Subject: Junction Rivers Wind Farm (SSD-30448824)

ATTACHMENT A – BCS and NPWS Assessment Summary for Junction Rivers Wind Farm Environmental Impact Statement (SSD-30448824)

ATTACHMENT B – BCS detailed advice for Junction Rivers Wind Farm EIS

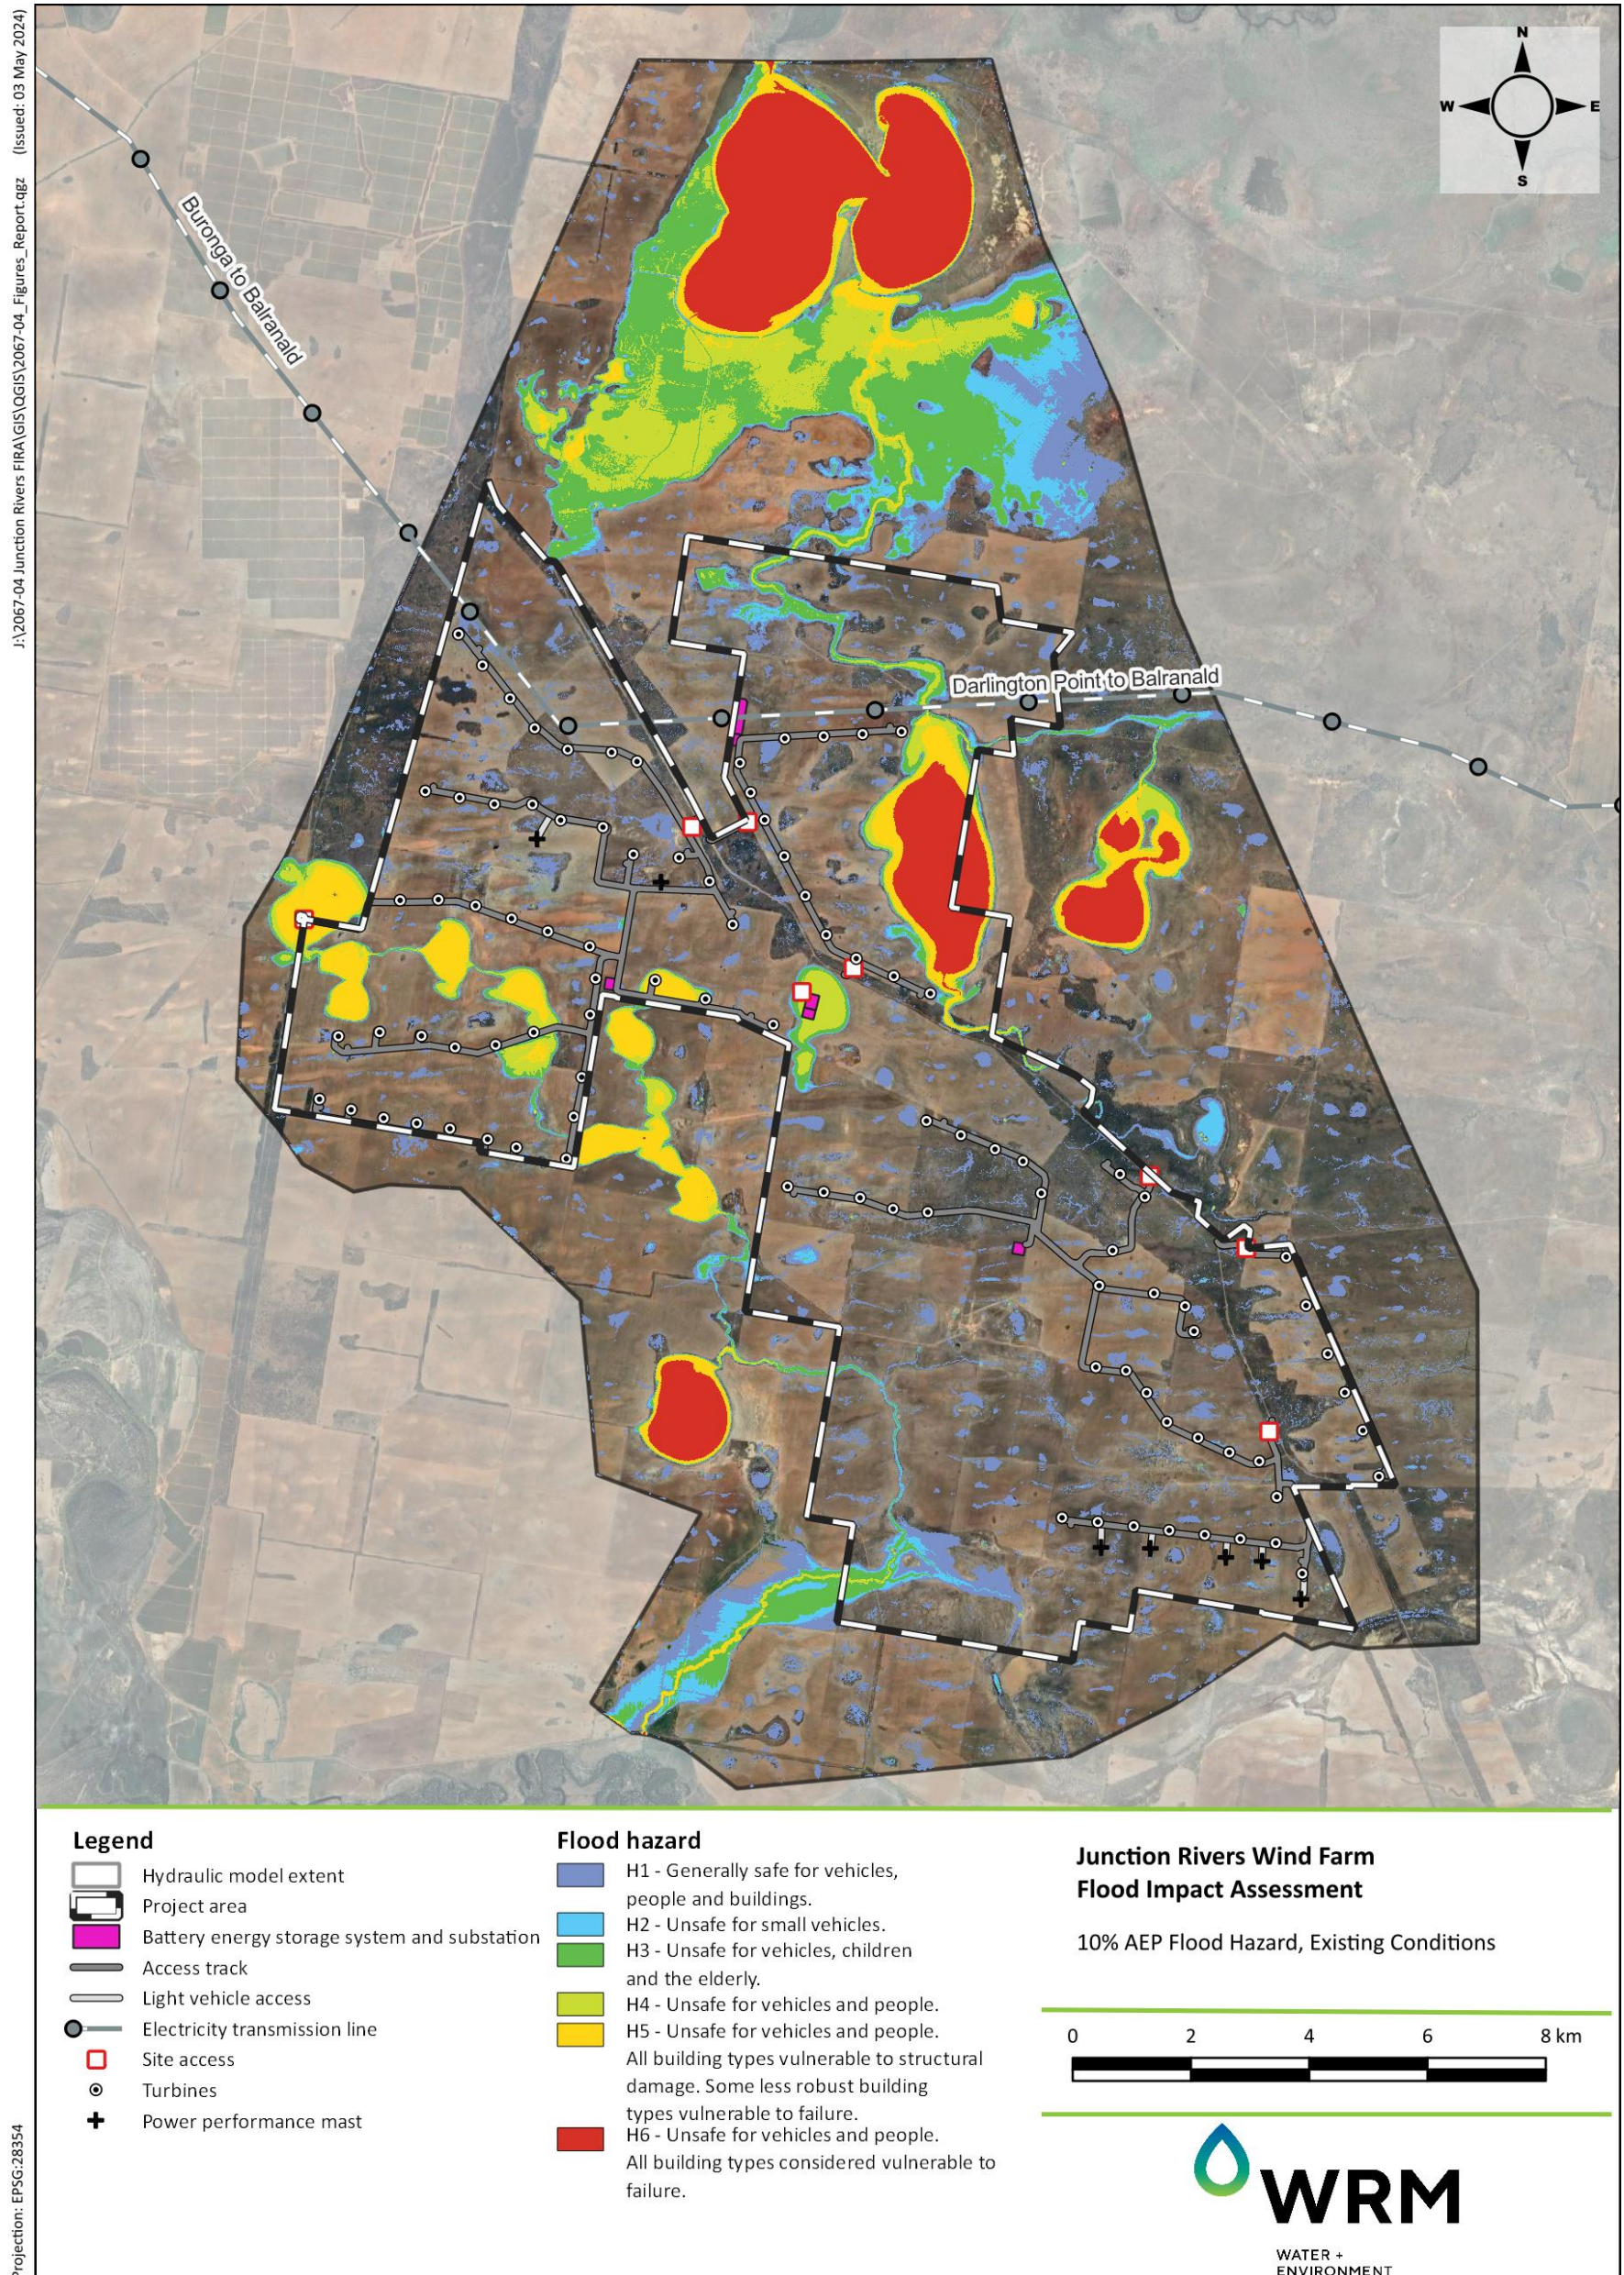
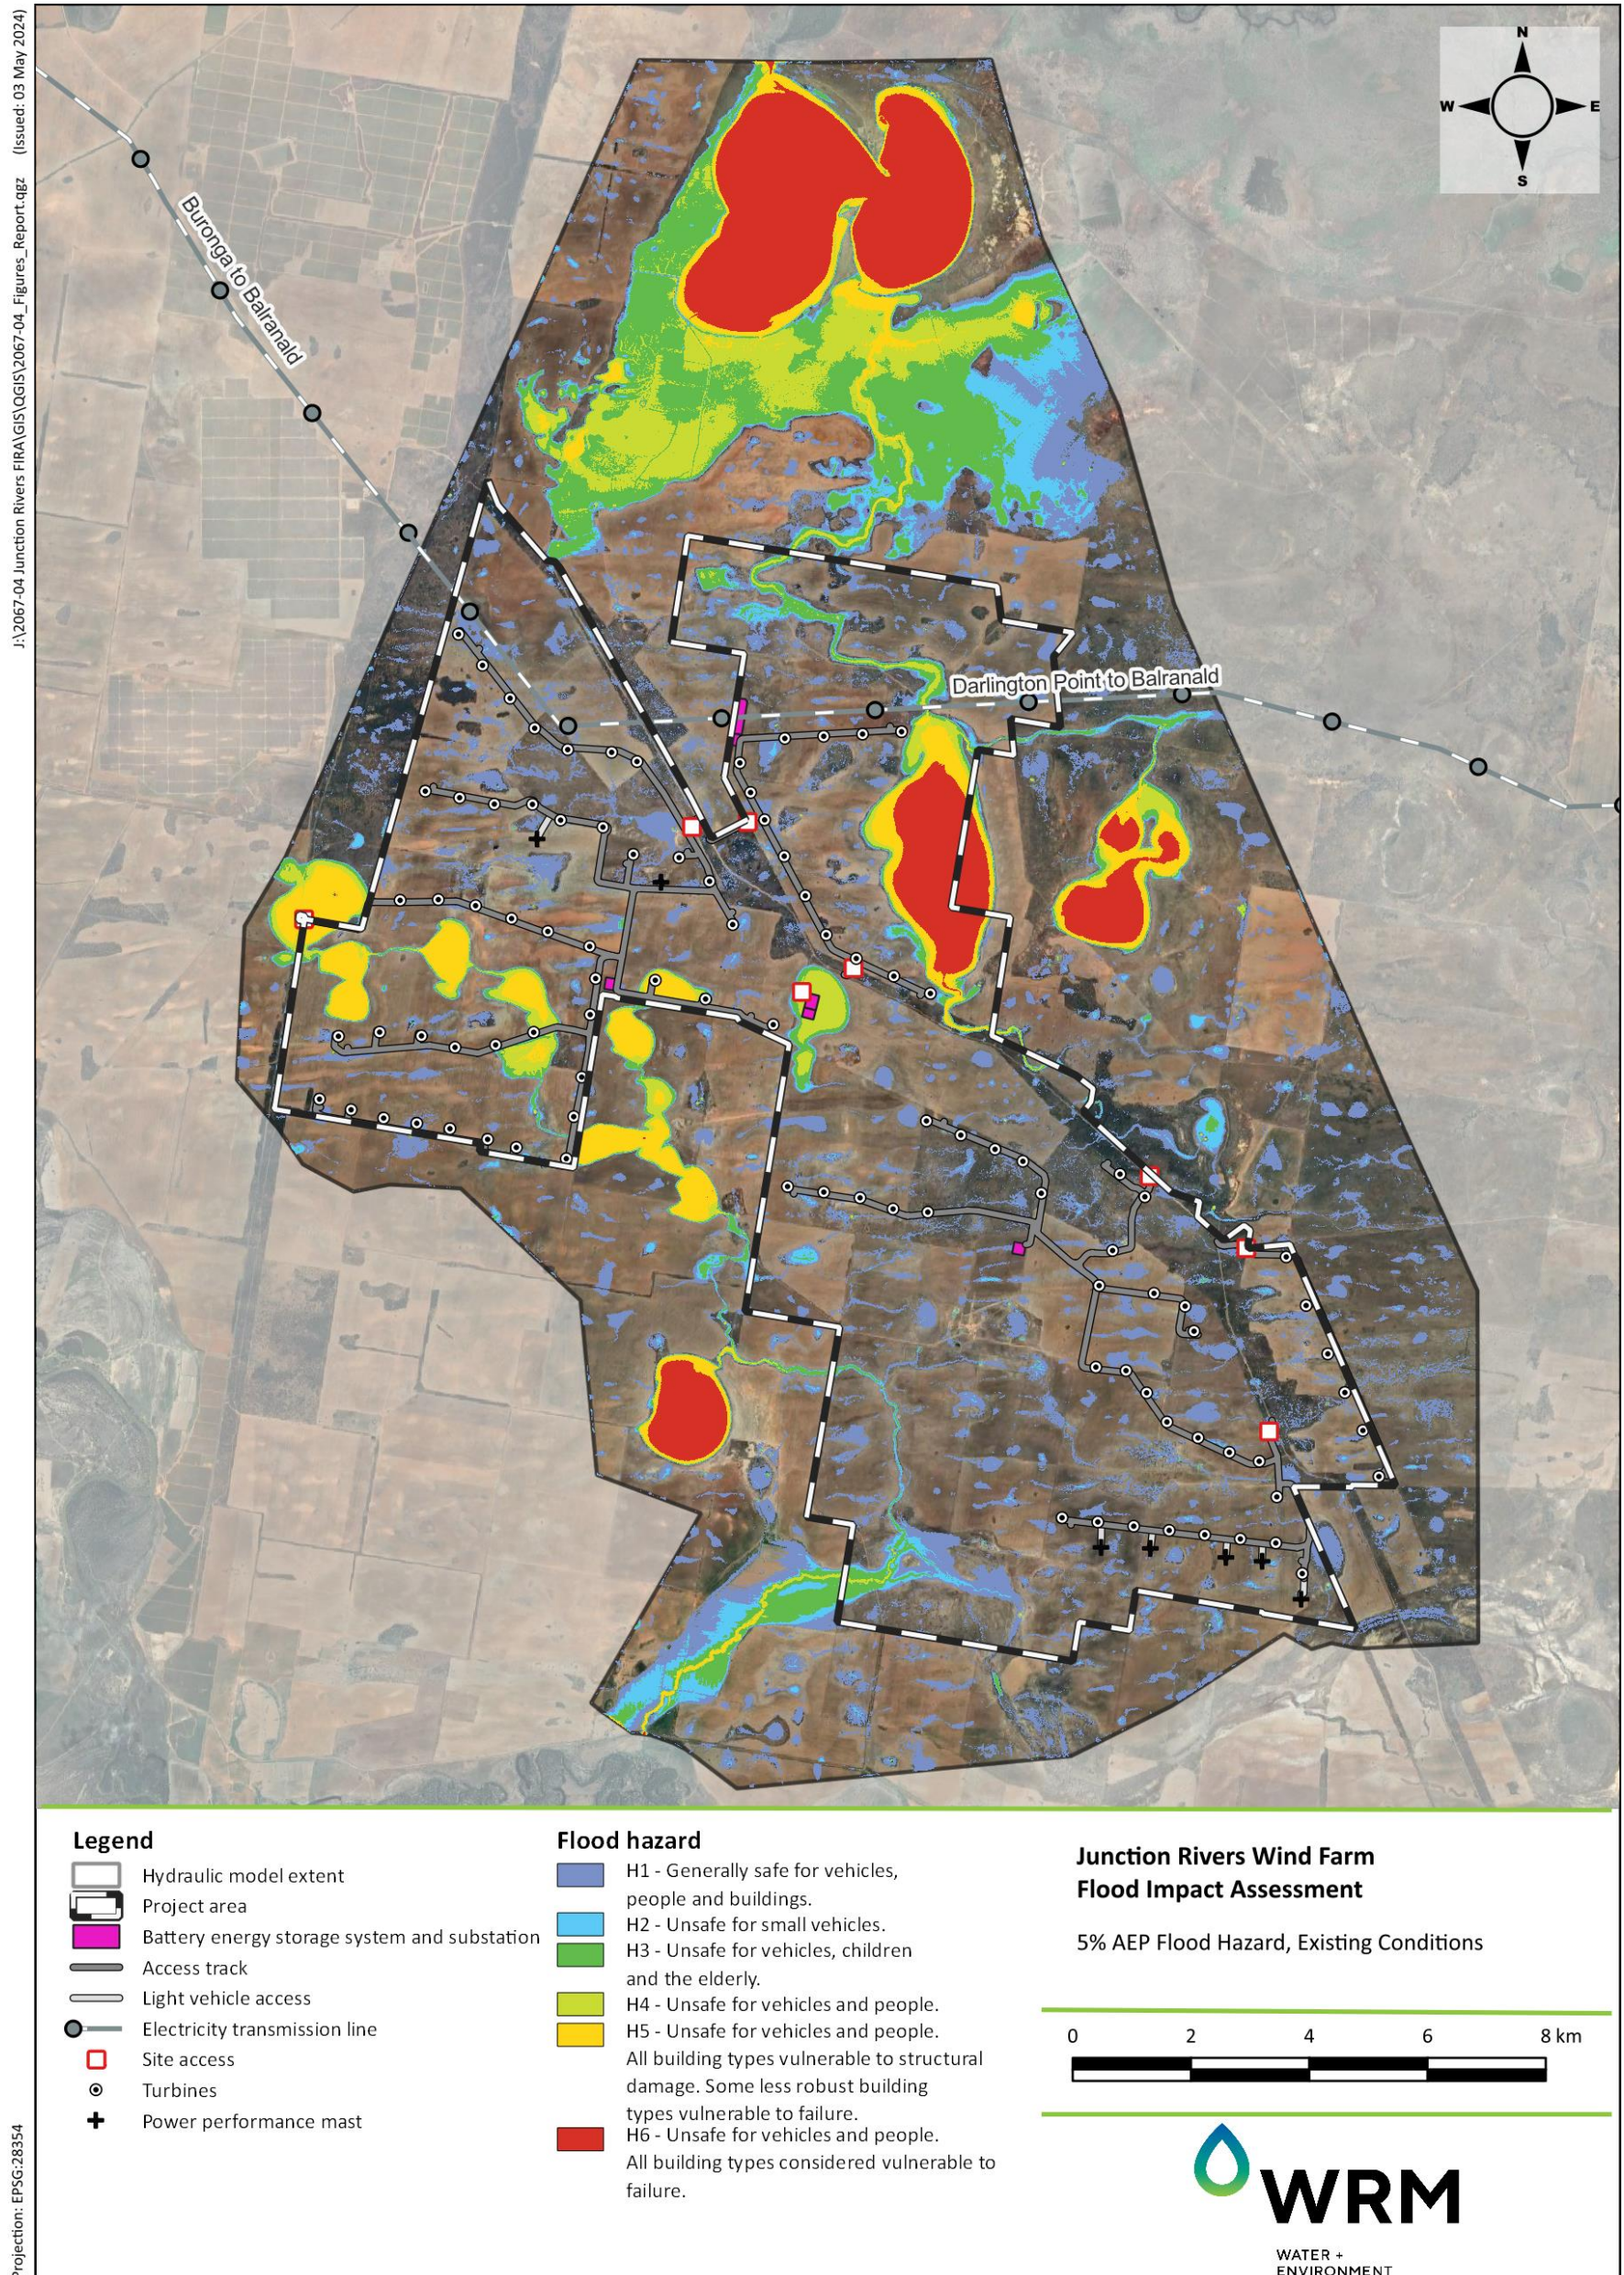
The proposed western and central site access points are located in high flood risk locations as shown in the design flood mapping in the Flood Risk Impact Assessment. BCS considers that these locations are incompatible with use as key evacuation egress routes in major flood events.

BCS recommends that more appropriate locations for flood emergency egress needs to be determined in the detailed design stage in consultation with local Councils and the NSW SES. The flood emergency evacuation egress locations and evacuation procedures need to be detailed in the proposed ERP along with the records of consultation with local Councils and the NSW SES.

- 2.1. Identify more appropriate locations for flood emergency egress for those site access points that are impacted by high flood risks in consultation with local Councils and the NSW SES.
